## Application for a Non-Material Amendment Following a Grant of Planning Permission

Land to the North of Cold Overton Road

2021/1334/RES

PROJECT : 2108 : LAND NORTH OF COLD OVERTON ROAD, LANGHAM
DWG NO : 2108 - 05 - PROPOSED PLANS & ELEVATIONS : PLOT 4 & 16
REVISION : b
SCALE : 1 : 100 @A1
DRAWN BY : SW

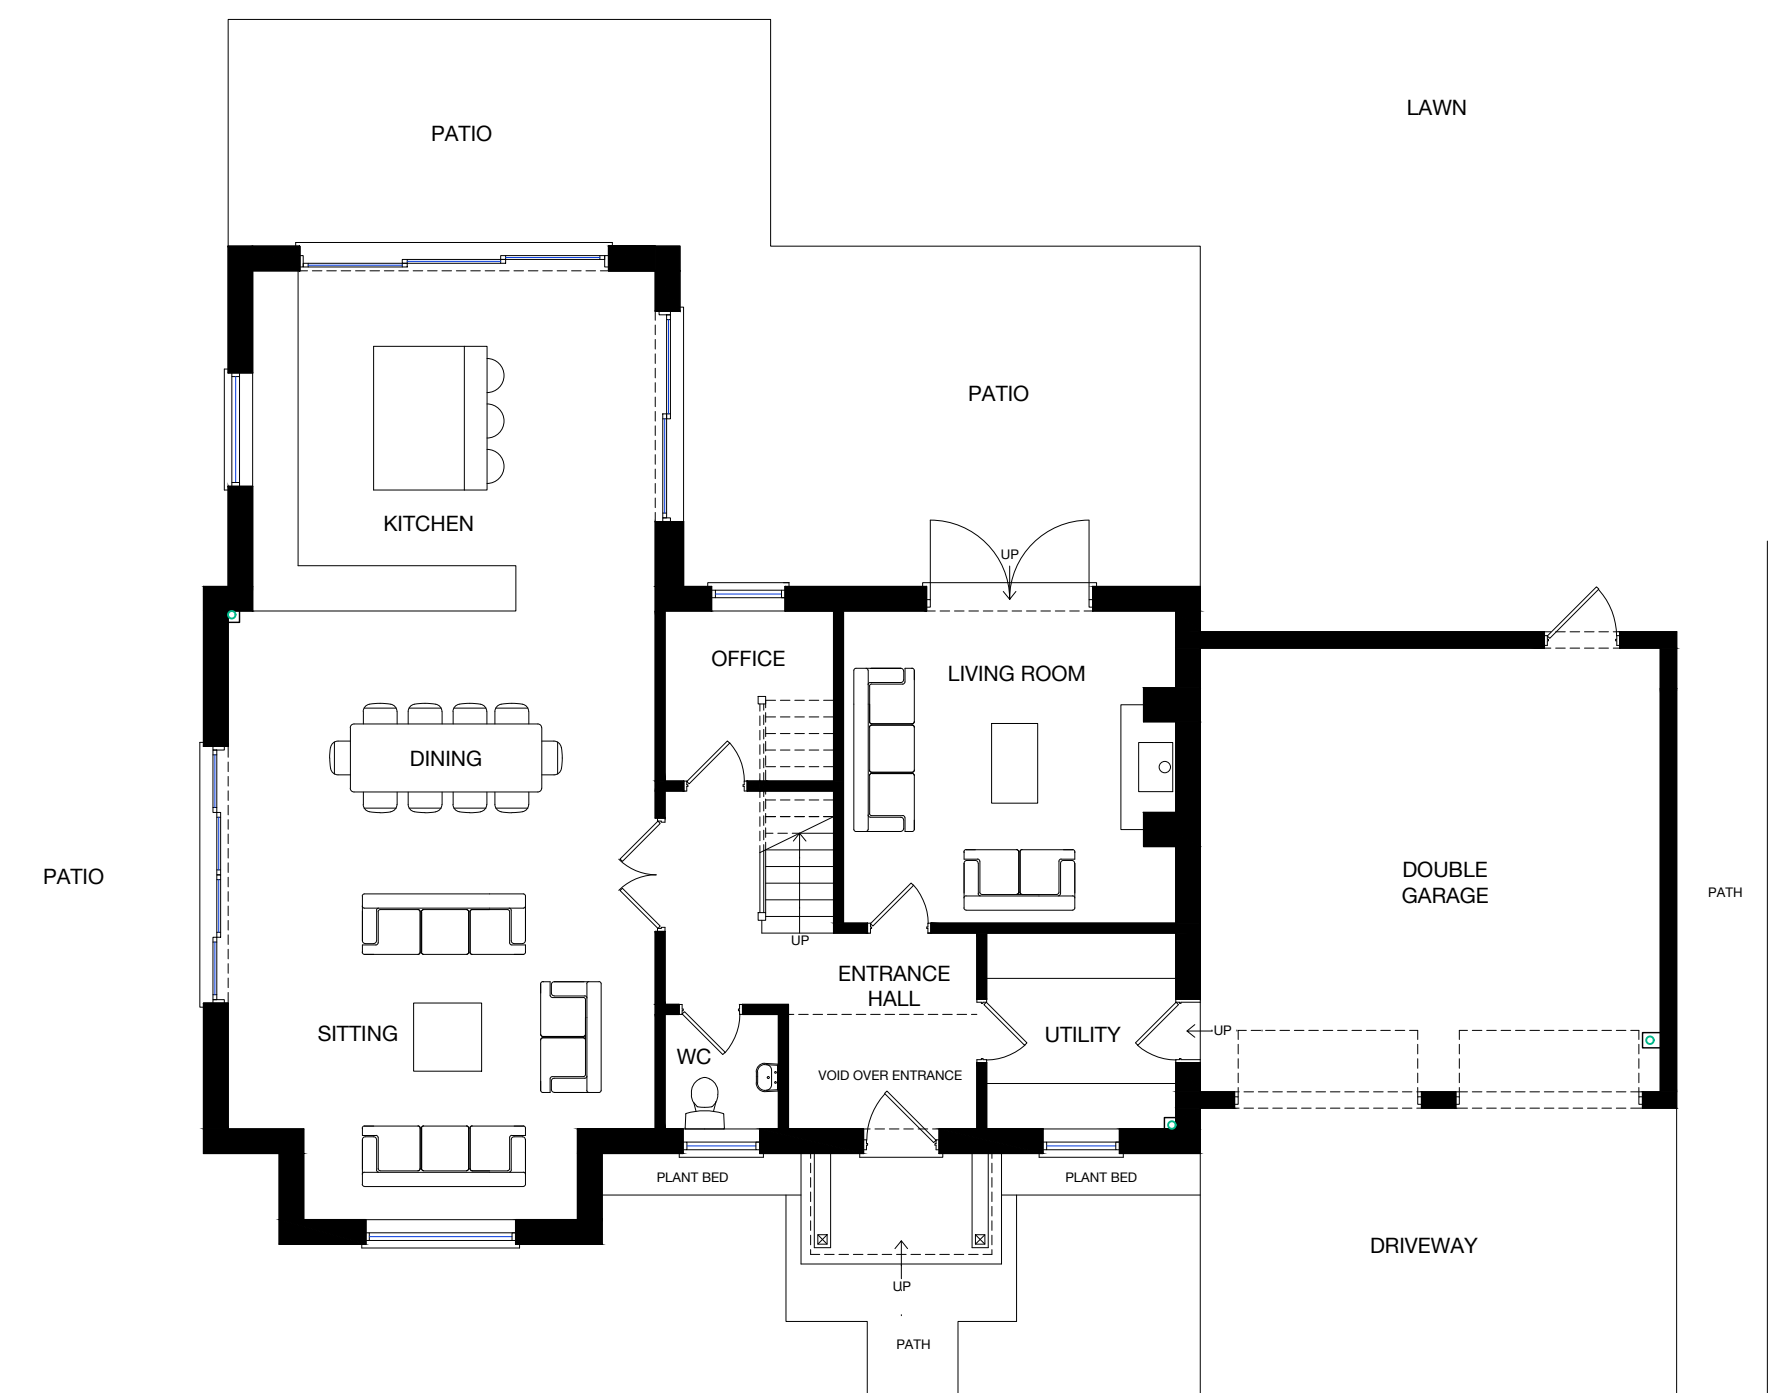
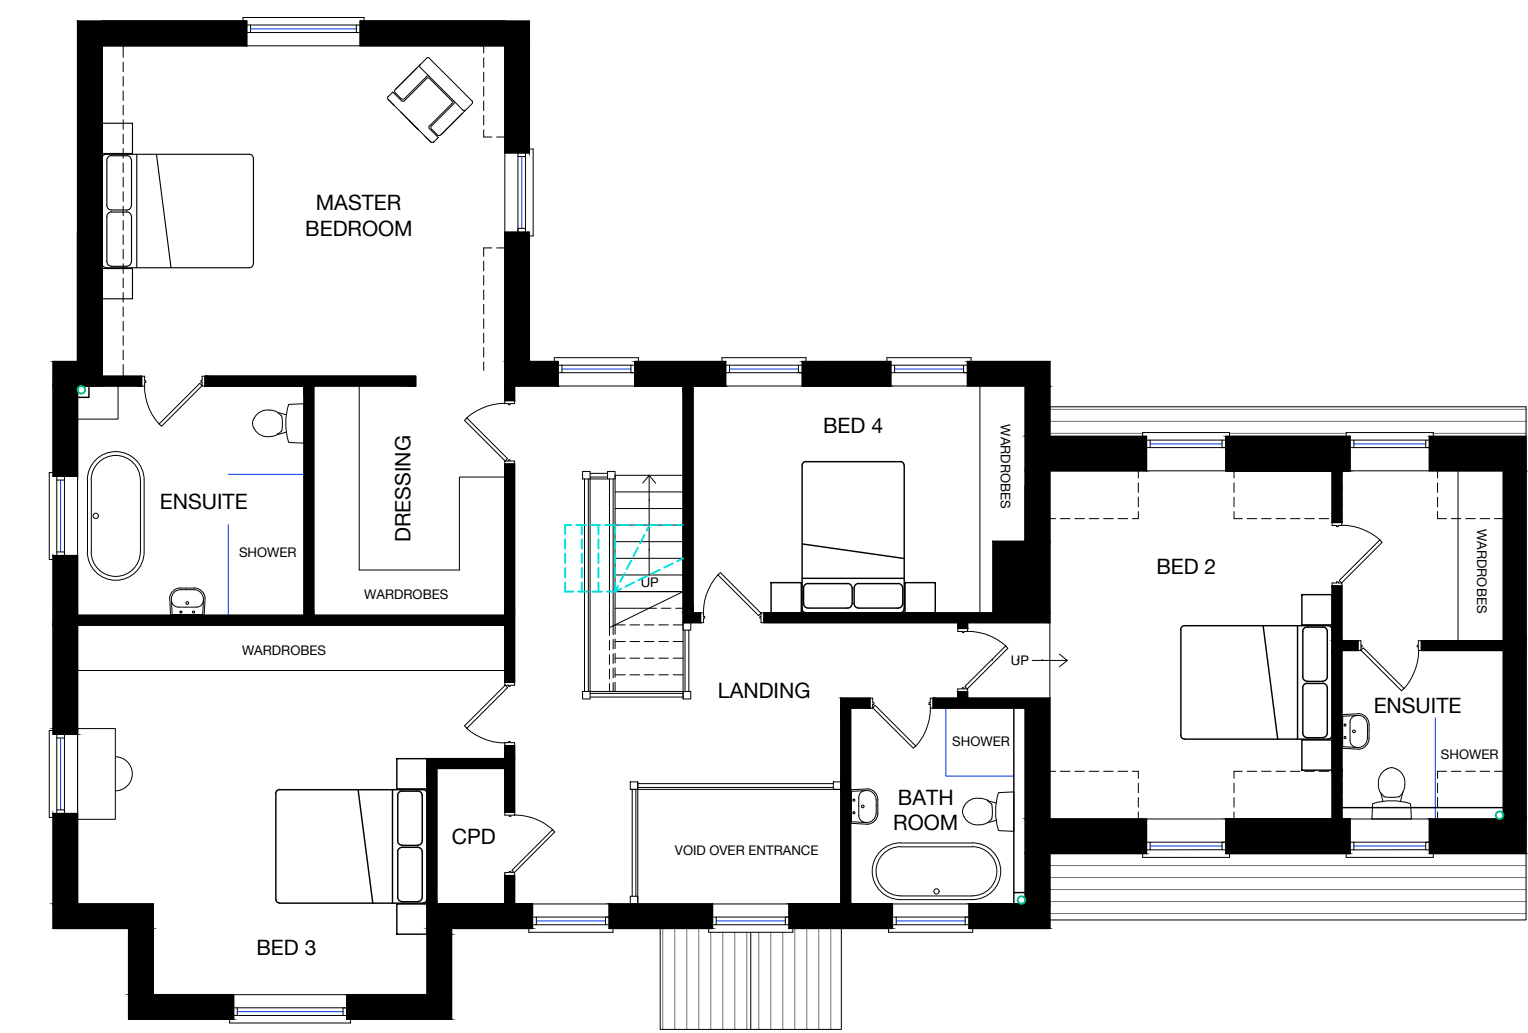
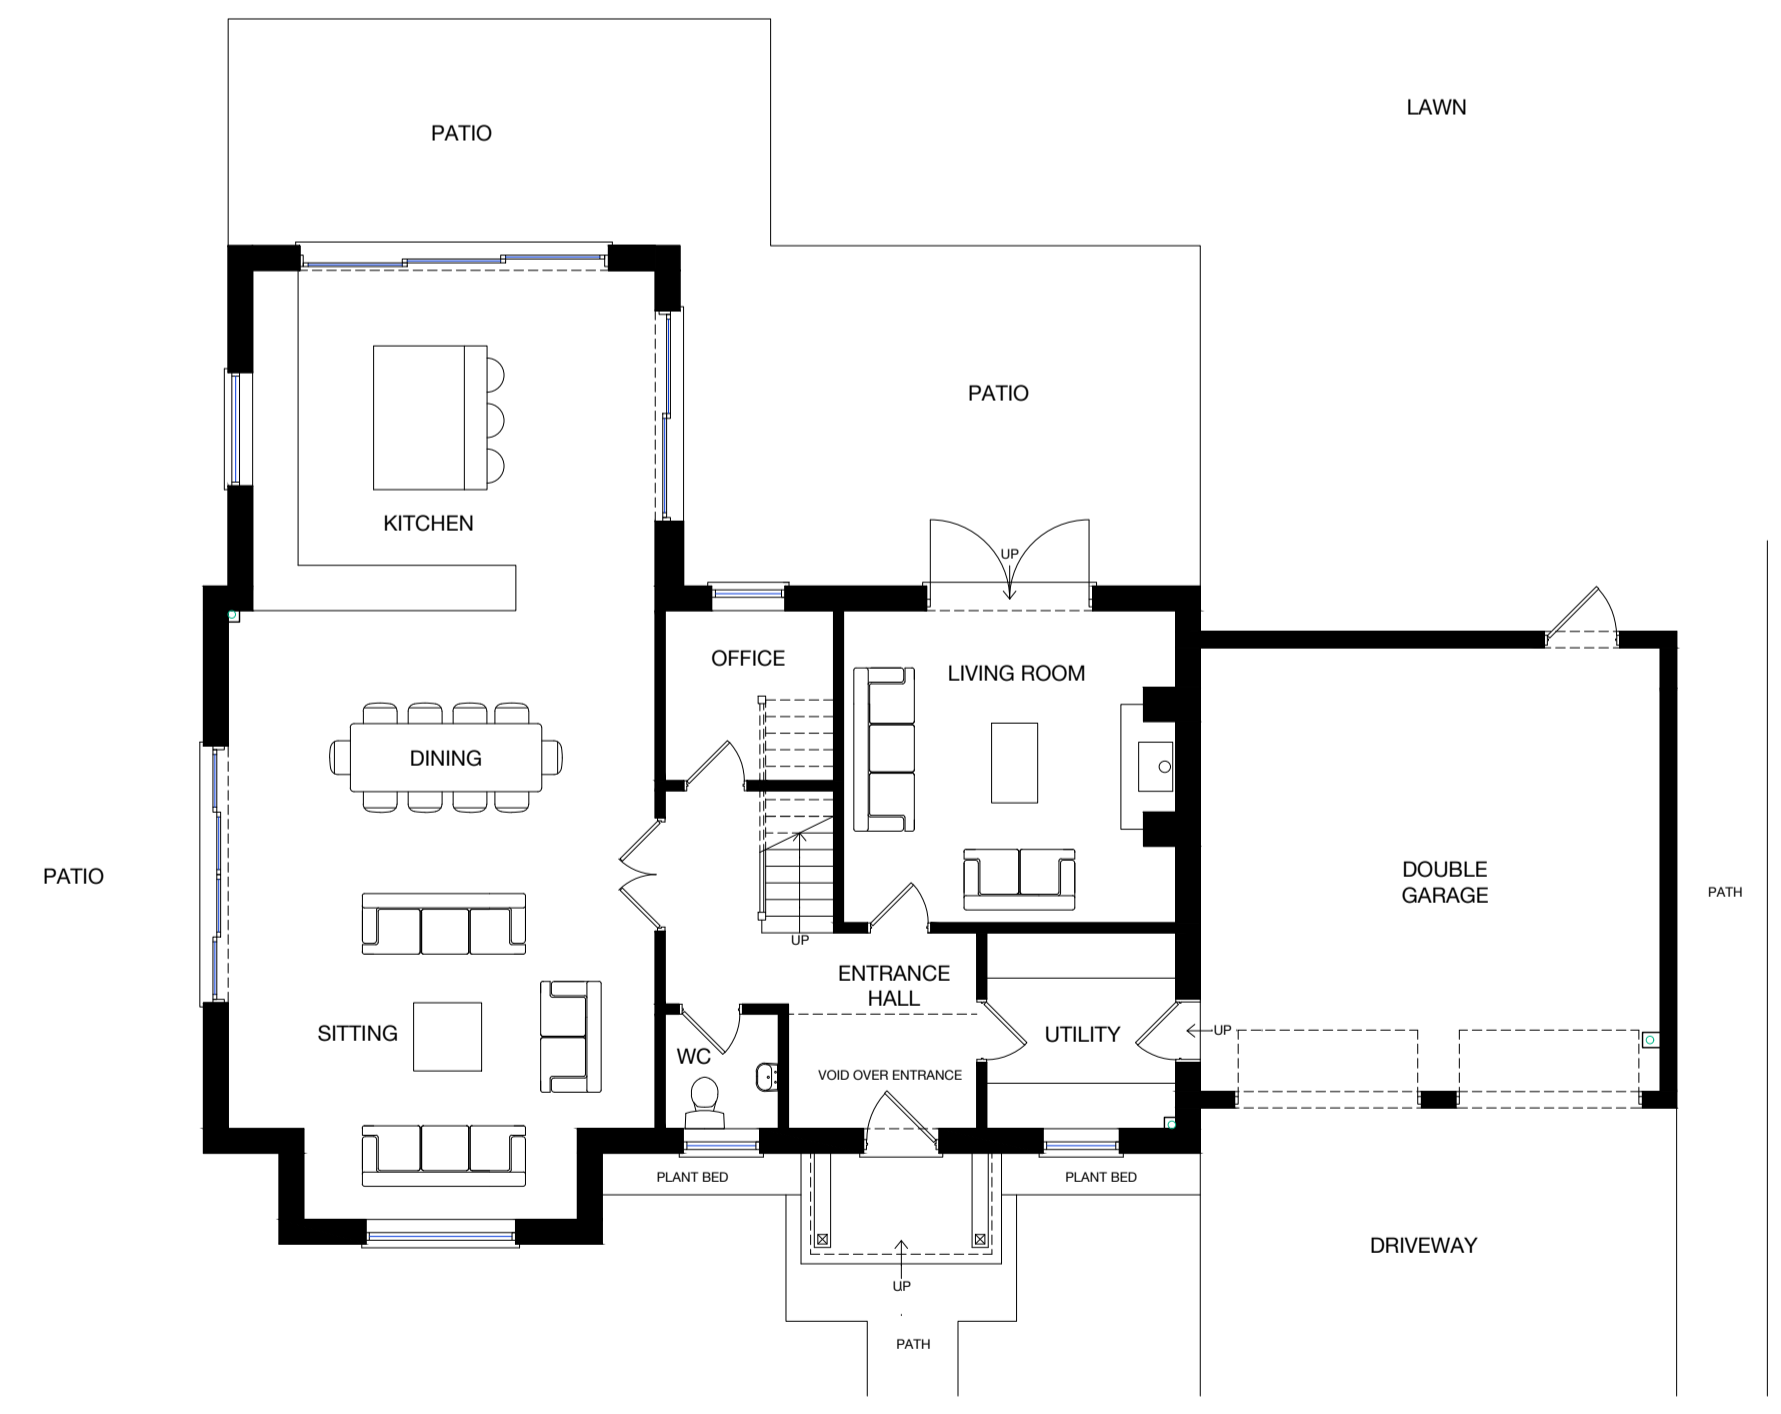
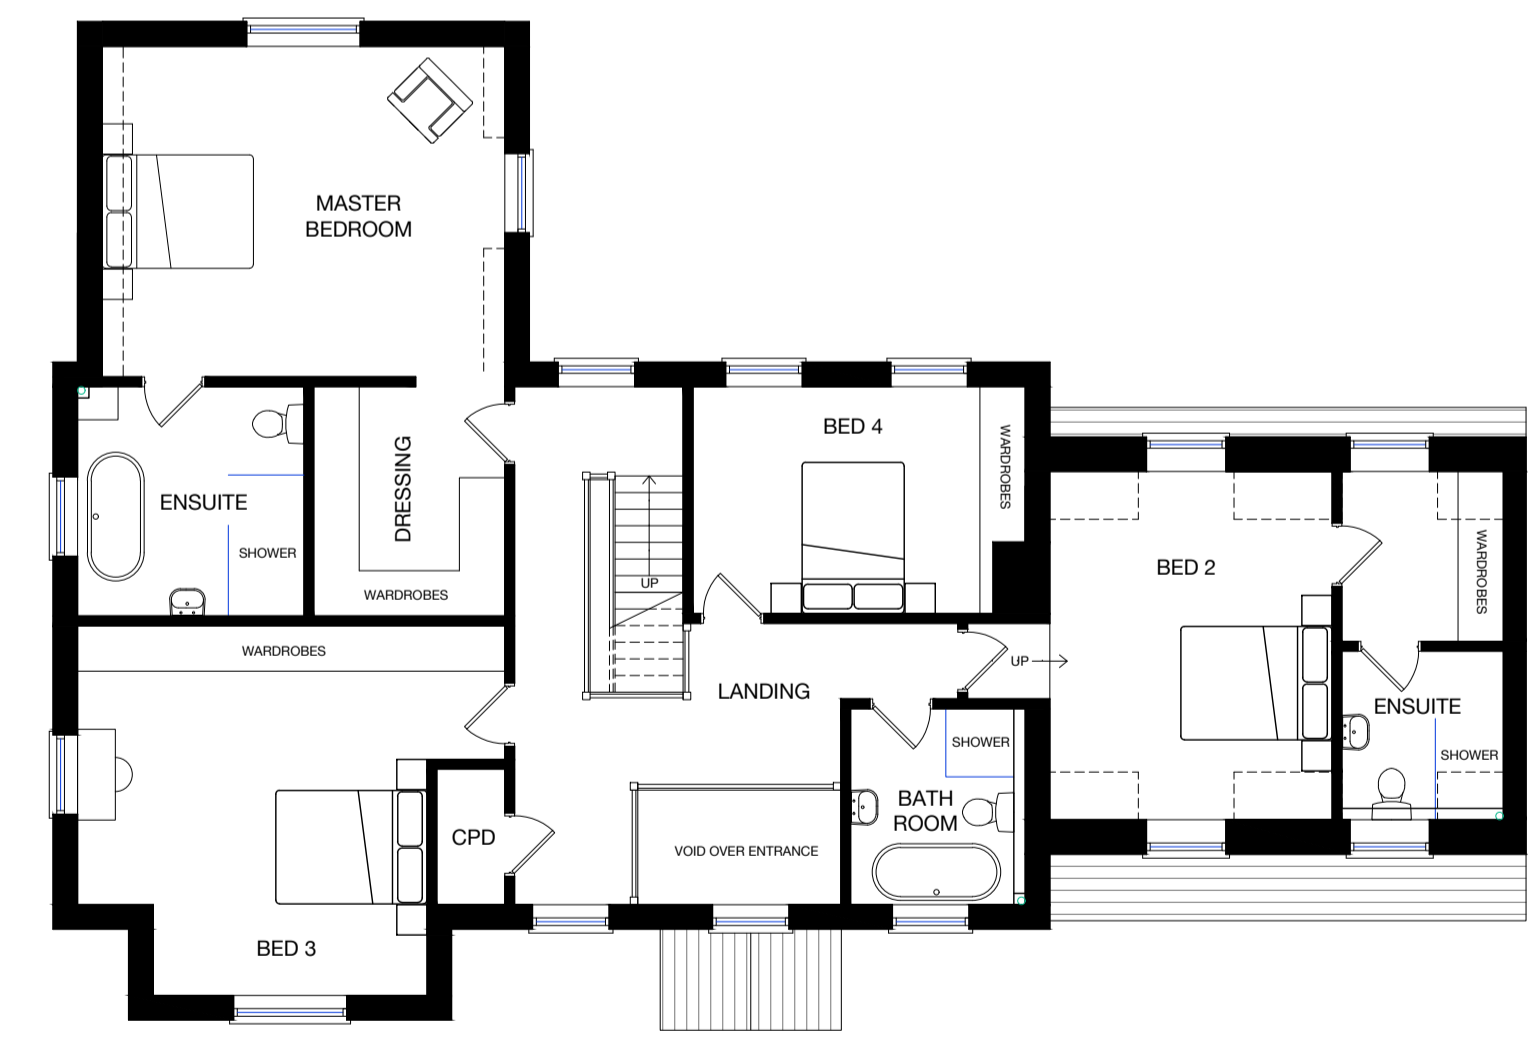
Amendments to the site layout to improve turning areas and minor alteration in the layout of plots 16 and 17, thus affecting the garden of plot 10.  
Minor alterations to the appearance of Plot 16 and 17 in response to the changes to the site layout.  
Landscaping plan updated to reflect changes to the improved site layout.

2108 - 01h - Proposed Site Plan  
2108 - 05b - Proposed Plans and Elevations Plots 4 and 16  
2108 - 14 - Proposed Plans and Elevations Plot 17  
GL1119 01E Detailed Landscape Proposals

2108 - 1000h - Proposed Site Plan with Levels  
2108 - 05c - Proposed Plans and Elevations Plot 4  
2108 - 14a - Proposed Plans and Elevations Plot 17  
2108 - 15 - Proposed Plans and Elevations Plot 16  
GL1119 01F Detailed Landscape Proposals
